## WEST SUSSEX COUNTY COUNCIL CONSULTATION

| <b>LOCATION:</b>                       | Land North of Water Lane<br>Angmering                                                                                                                                                                       |
| <b>SUBJECT:</b>                        | A/256/21/RES<br><br>Approval of reserved matters following outline consent A/40/18/OUT for the erection of 525 No residential dwellings with associated parking, landscape, play areas & public open space. |
| <b>RECOMMENDATION:</b>                 | More Information                                                                                                                                                                                            |

3. Bus and emergency vehicle access from Dappers Lane (iTransport)

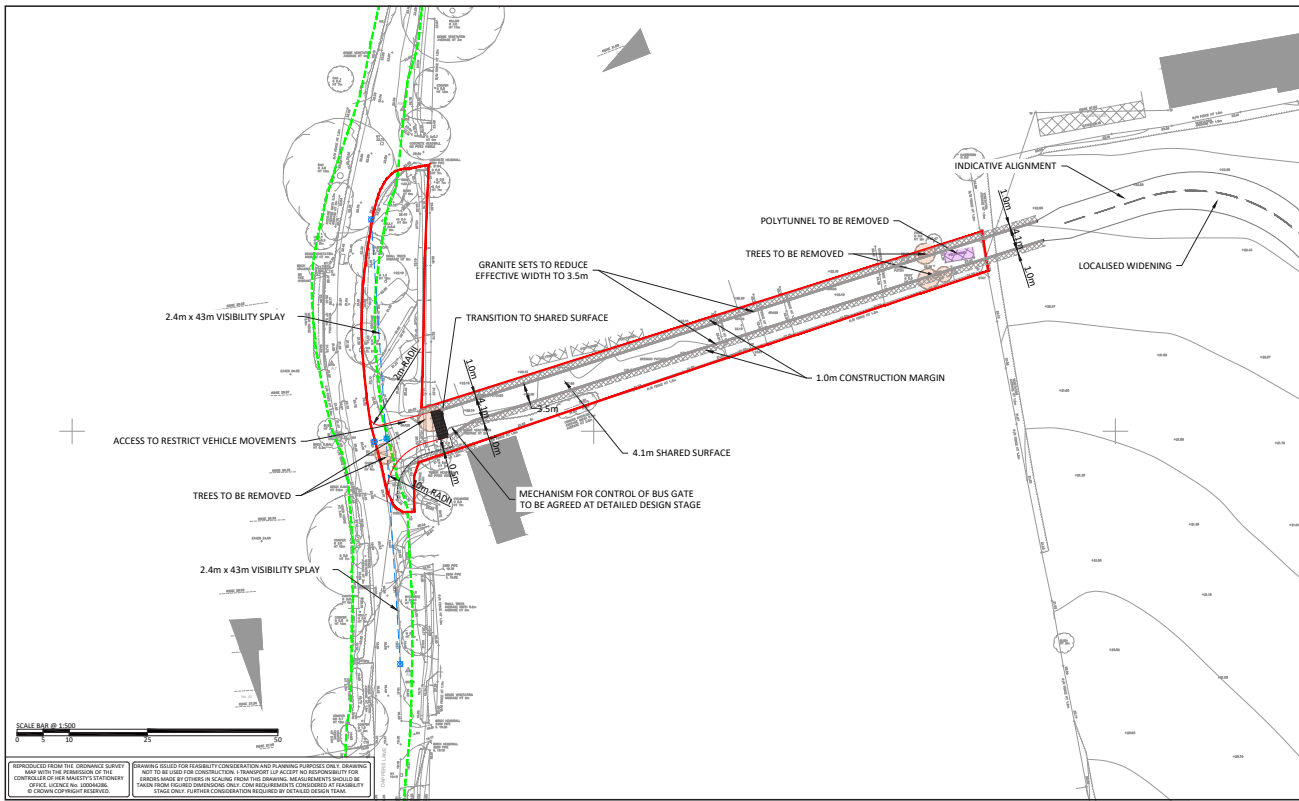
As the width of the bus gate does not allow 2 buses to pass, forward visibility/details of directional priority should be provided.

4.13 Refuse Collection Strategy and Tracking

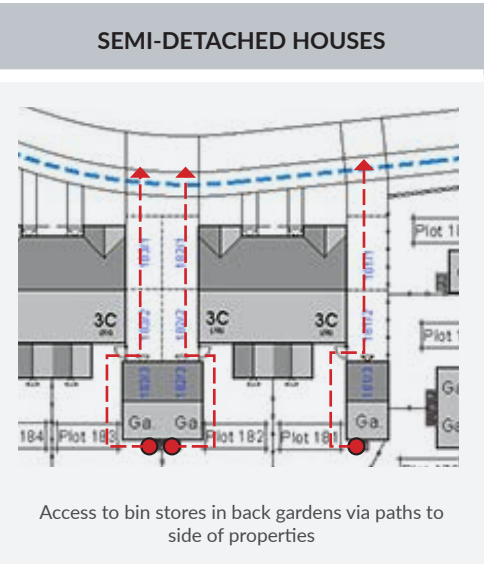
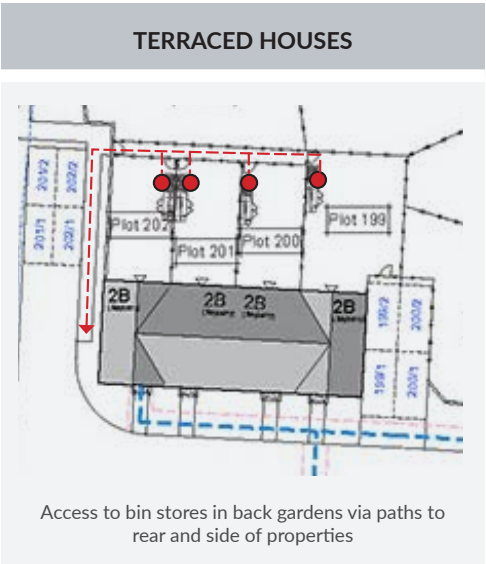
The refuse vehicle tracking should be rechecked by the applicant, in a number of locations the tracking over runs residential and visitor parking spaces.
